***Garvan St Vincent's Campus Cancer Centre,  
Darlinghurst***

***MP 09\_0011 MOD 1 – Modifications to  
building alignment; northern façade signage  
and ground floor tenancy use***

Director-General's  
Environmental Assessment Report  
Section 75W of the  
*Environmental Planning and Assessment Act 1979*

**November 2012**

PLAN

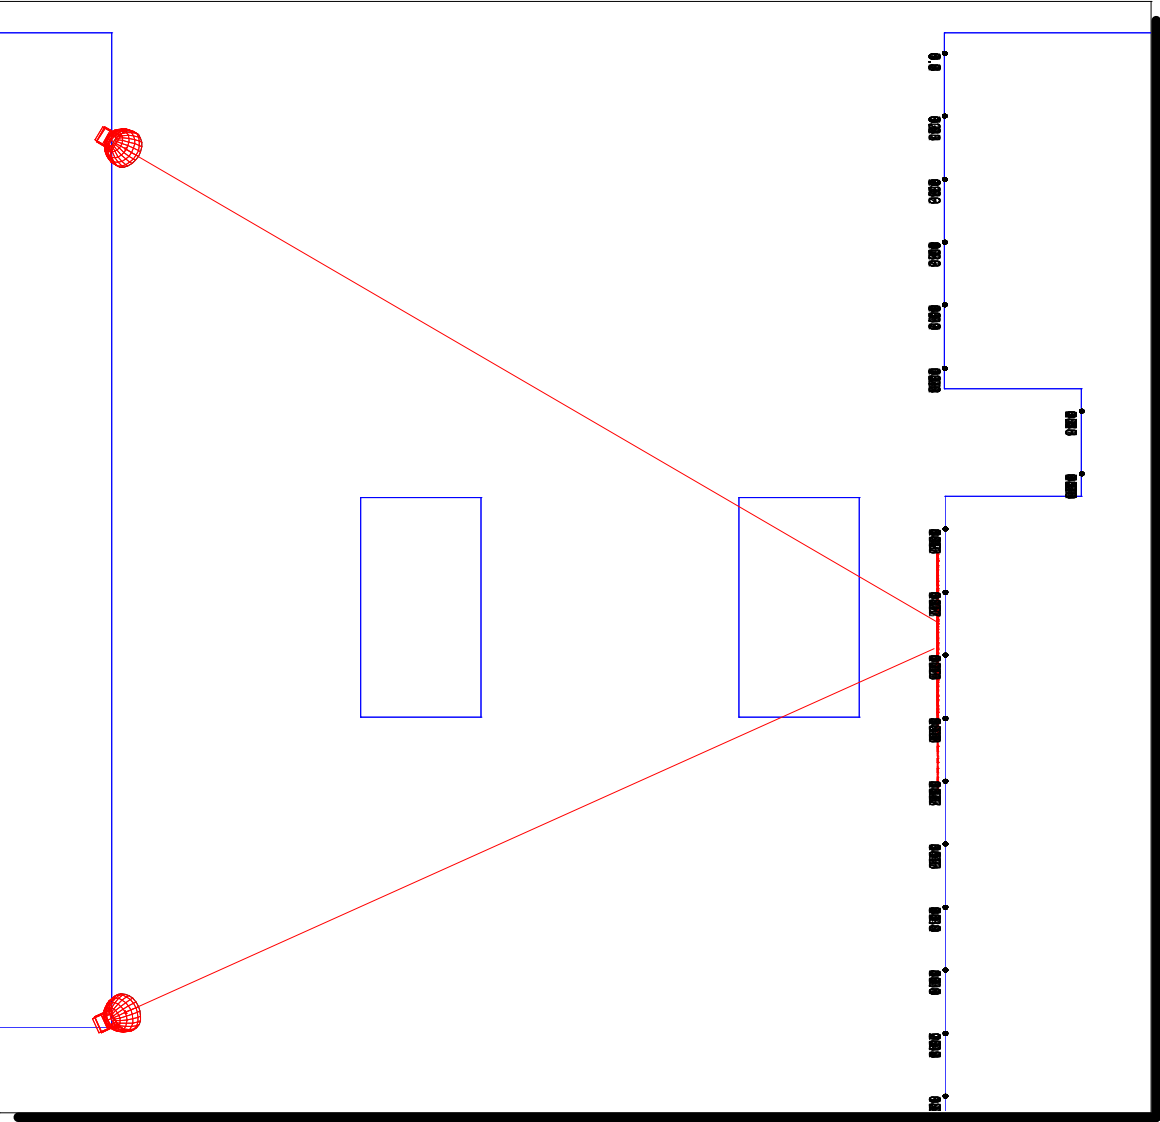
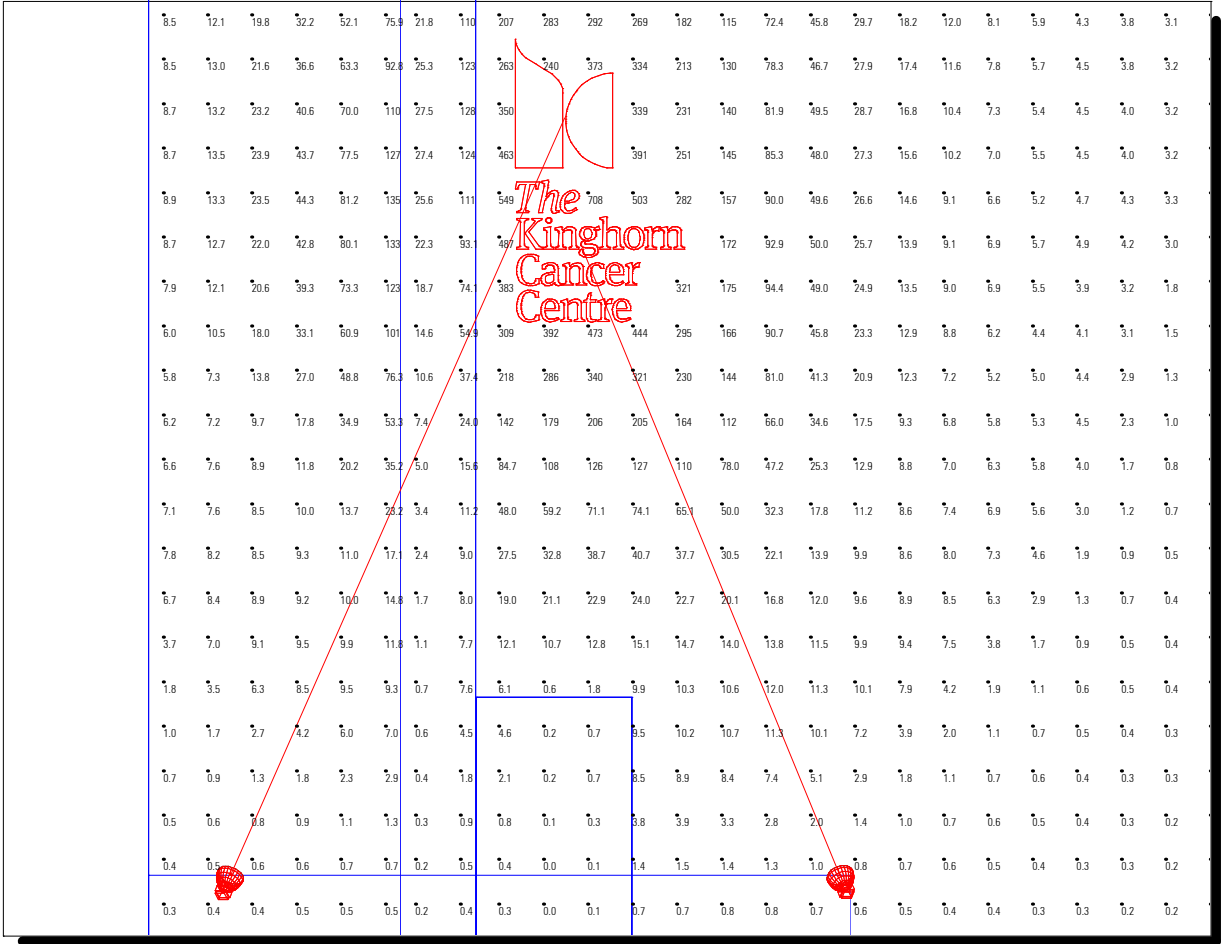
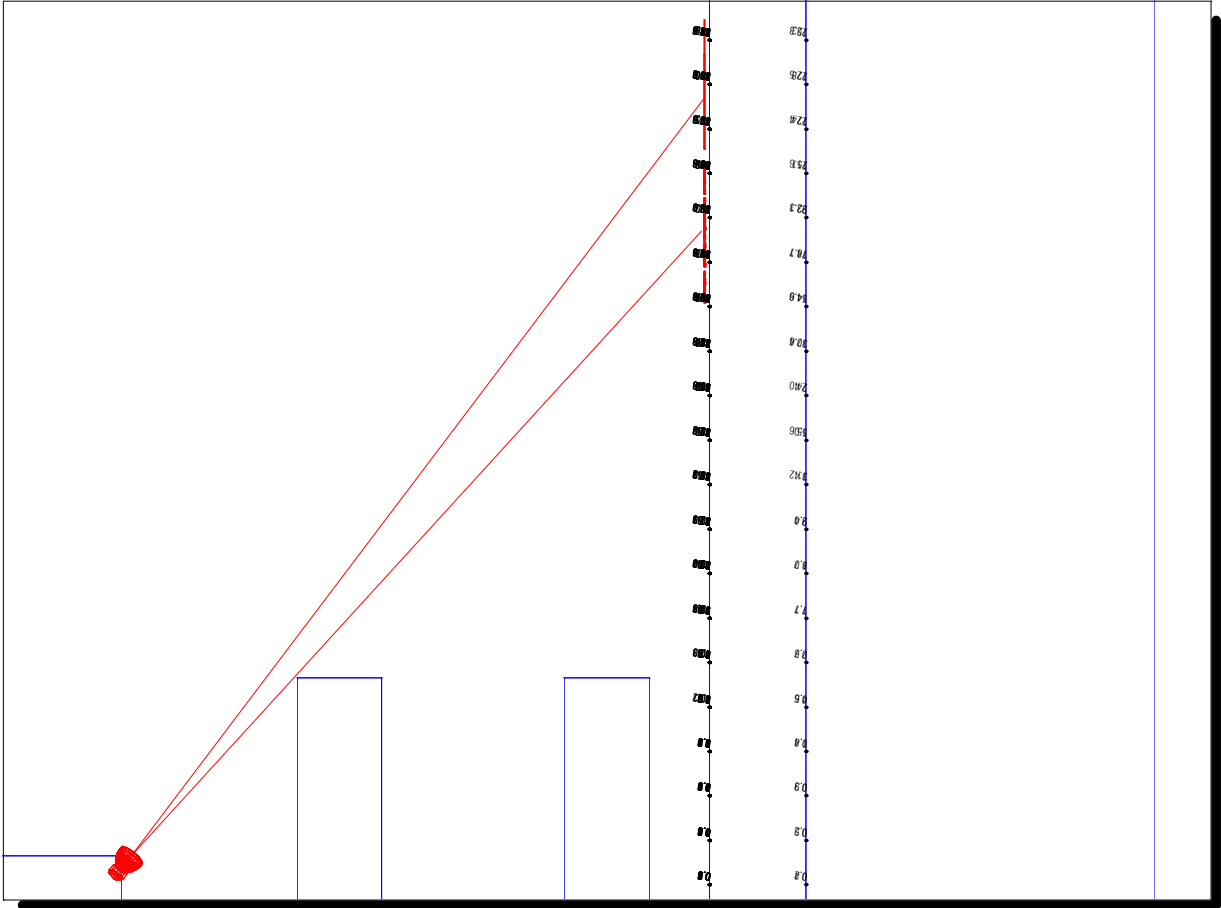
Council indicated that any signage should not be too bright or flash and should not result in light spill beyond the signage. The proponent indicated that a light analysis has been undertaken showing light spillage to be at an acceptable level, particularly as the light is angled away from residential development.

Figure 2: Proposed illumination of the Kinghorn Cancer Centre sign

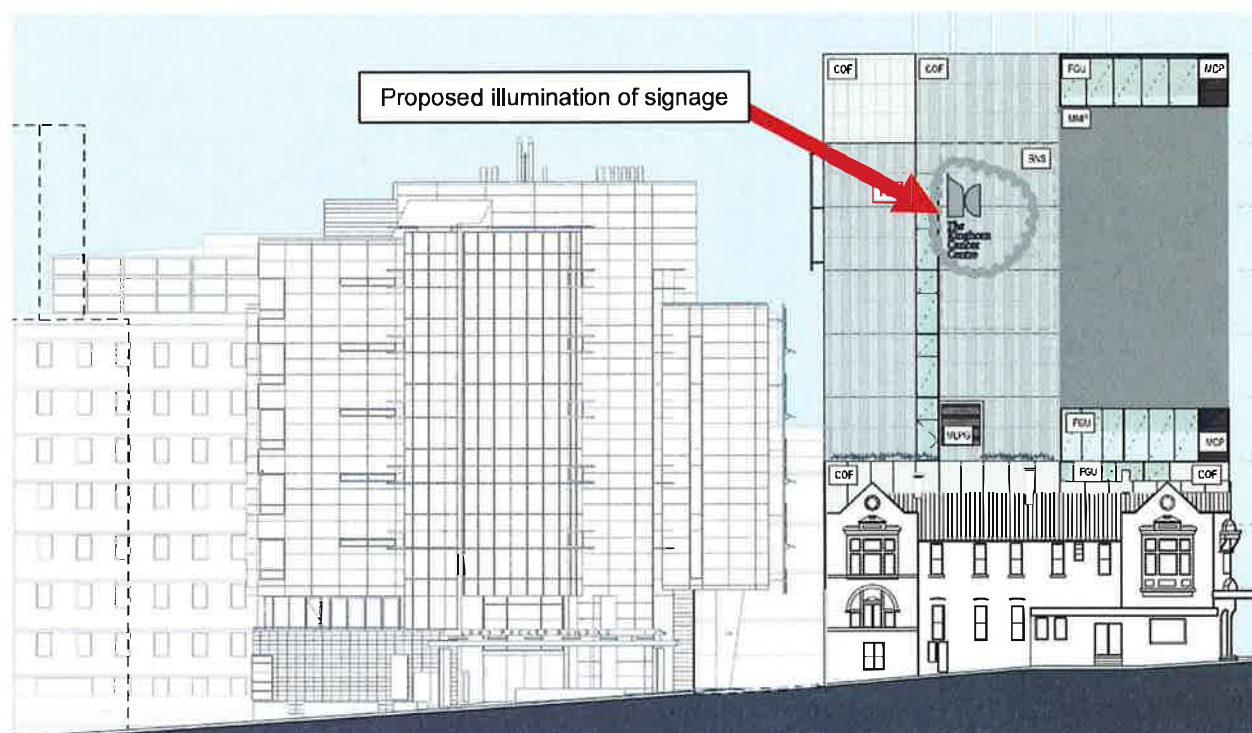
The proposal seeks to modify an existing approved sign by illuminating the 'Kinghorn Cancer Centre' logo on the Kinghorn Cancer Centre northern façade. The signage is to be illuminated at night by two 440 watt spot lights, which will shine from either side of the sign from level 6 below, as shown in **Figure 2**. The signage is to be constructed from steel plate with a matt finish to limit glare.

On this basis, the Department considers that the proposed signage modification is acceptable given that:

- the signage will be orientated away from residential developments;
- the signage will be constructed from steel plate logo with matt finish to limit glare; and
- the signage is consistent with the objectives of AS4282-1997 and State Environmental Planning Policy No. 64 – Advertising and Signage.

Figure 3: Location of the proposed café within the Kinghorn Cancer Centre

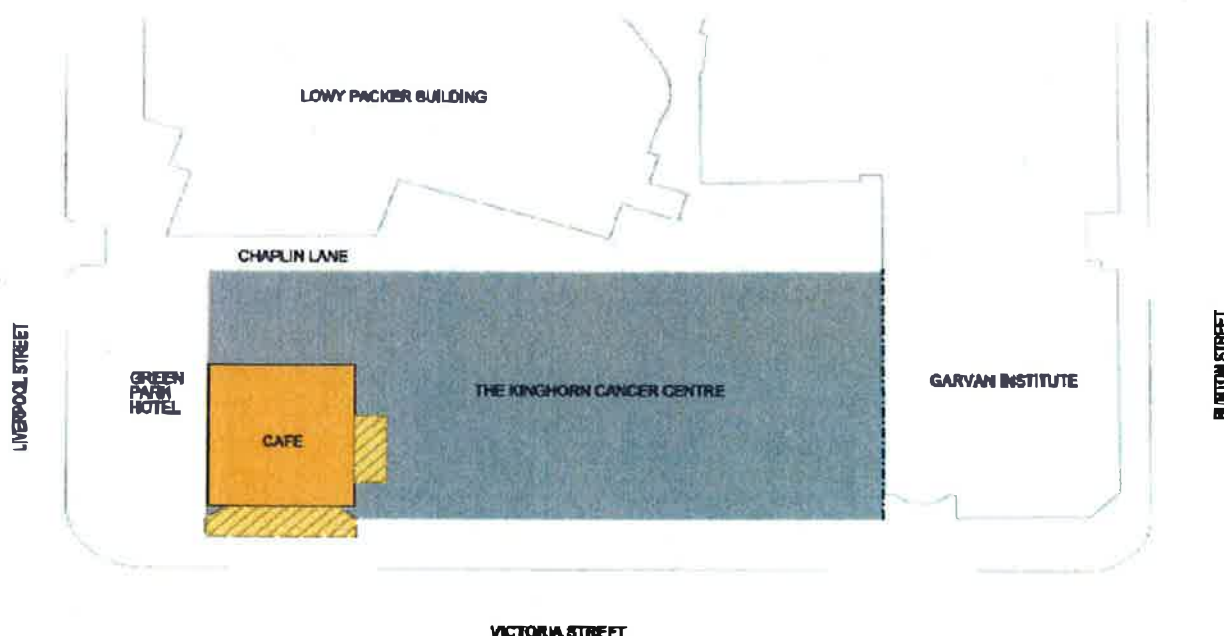
Council have recommended that measures be implemented to ensure the premise is used solely as a café and restrict any changes to this use. The proponent has indicated that the application is for a café, therefore the Department will assess the merits of this application based on this provision.

Council noted that the proposal does not provide for mechanical cooking exhaust, therefore no food should be cooked on site. The proponent indicated that food items sold on site will not be prepared at the premise.

Therefore, the Department is satisfied that the proposed use of the ground floor tenancy is consistent with the original project approval.

Figure 4: Victoria Street Elevation of proposed cafe

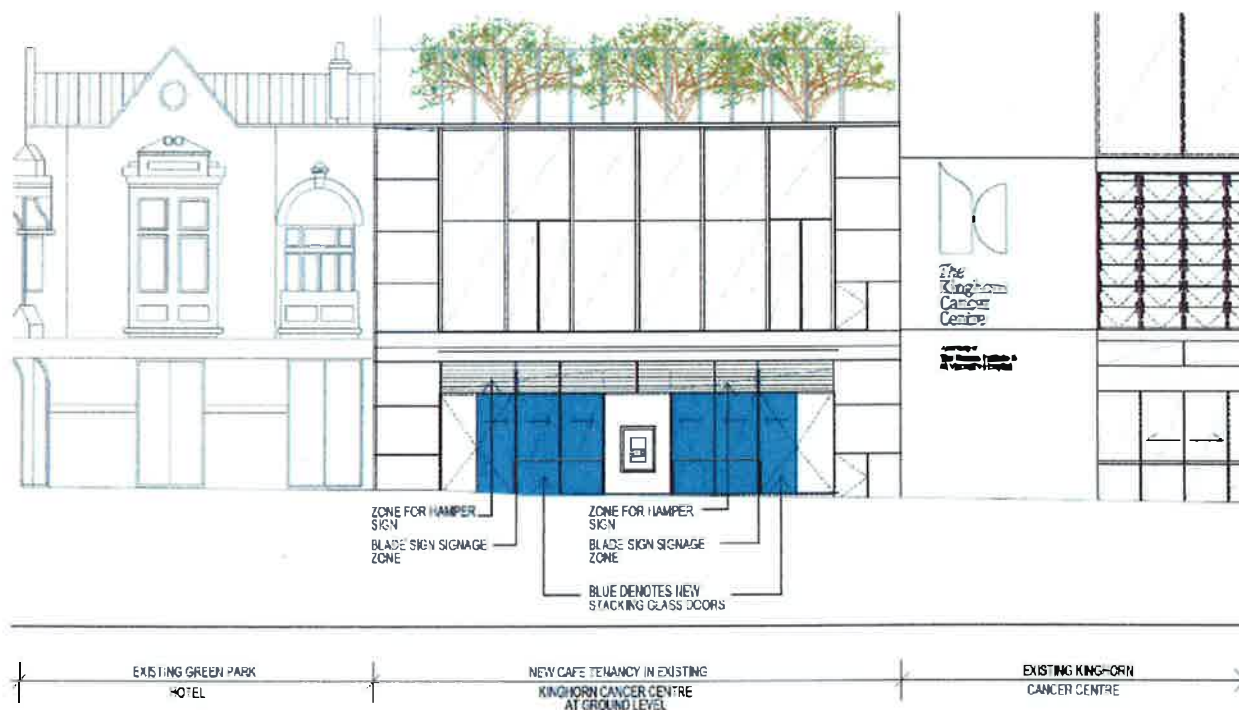
The modification also seeks to install folding doors at the tenancy entrance, as shown in **Figure 4**. Council raised concerns over the proposed glass sliding doors for the café and whether the noise generated from opening of the doors will impact on the local amenity. The proponent revealed that many uses along Victoria Street operate with their doors open to allow for street activation. The proponent has also acknowledged that doors are not to remain open after 10pm Monday to Sunday. The café will not generate unacceptable acoustic impacts on the locality, particularly when viewed in context with the surrounding late night trading establishments.

On this basis, the Department considers that the proposed modification will not produce adverse impacts on amenity given that:

- the premise is located in close proximity to other late night uses;
- extended trading hours are subject to a 1 year trial period to allow for ongoing monitoring; and
- the opening and closing of doors is consistent with the objectives of City of Sydney's Late Night Development Control Plan.
